# M25 junction 28 improvement scheme

TR010029

## 10.1 Report on Proposed Scheme Changes 1-4

February 2021

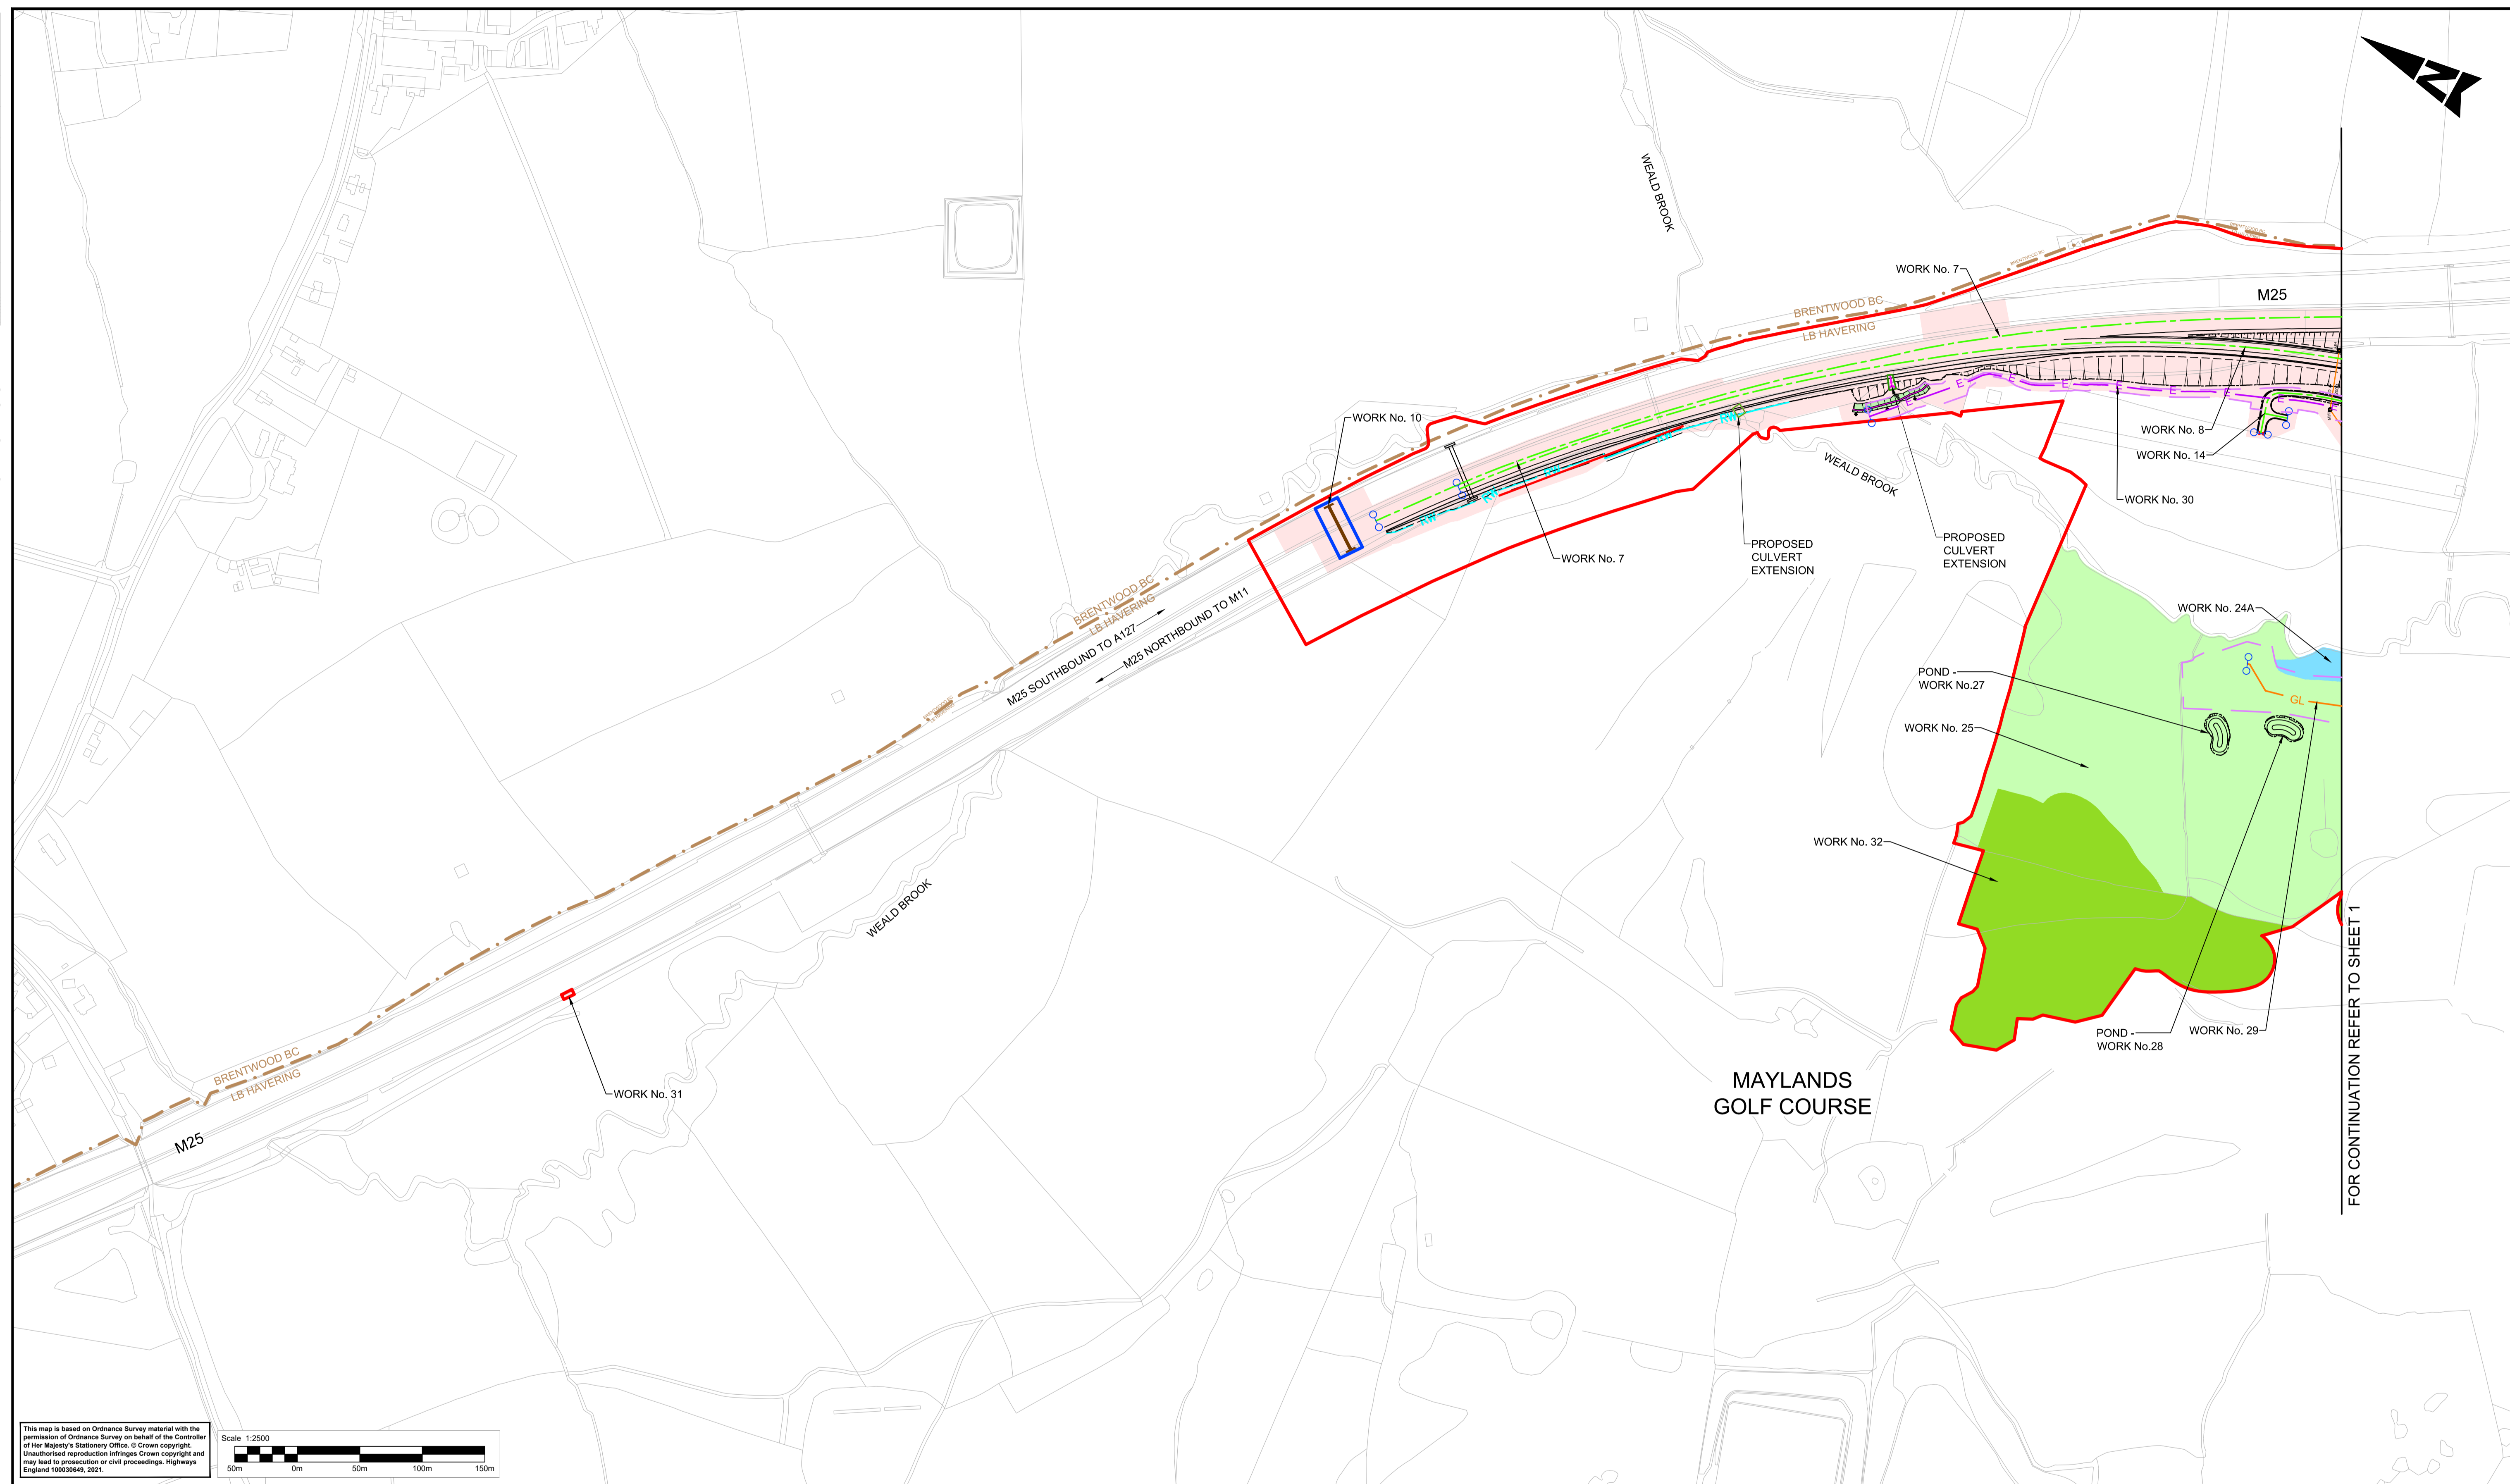
- 4.1.1 Highways England included two surplus construction material areas (Work No. 17 and Work No. 18) in the Application. Following feedback from the Environment Agency, it is proposed to remove Work No. 17 from the Scheme (see Change 1 above) and remodel Work No. 18 from an area of deposit for surplus construction materials into an environmental bund which follows the outline of the environmental works (part of Work No. 25) alongside the new loop road and to the north of Work No. 19B (a drainage pond and associated access).

- 4.1.2 The proposed environmental bund would be approximately 2.5 m high (with a vertical limit of deviation of 1 m upwards or downwards) and will be mainly grassed with a strip of woodland planting along the south and eastern sections of the bund. The bund will be designed in a reverse letter L-shape, running east-west generally parallel to the A12 and then north-south in parallel to the proposed loop road (Work No. 6) with an overall site area of 25,565 m<sup>2</sup>.

- 4.1.3 Incorporated into the design of the bund is a flat grassed area approximately 3 m wide along its western edge - known as a berm – to enable vehicular access for future maintenance. The environmental bund would provide predominantly visual benefits and some very limited noise screening benefits to the residents at Maylands Cottages, as well as to the users of Maylands Golf Course. Figure 4.1 below shows an outline of this change, with full details provided on the Scheme Layout Plans, Works Plans and Land Plans (TR010029/EXAM/10.2).
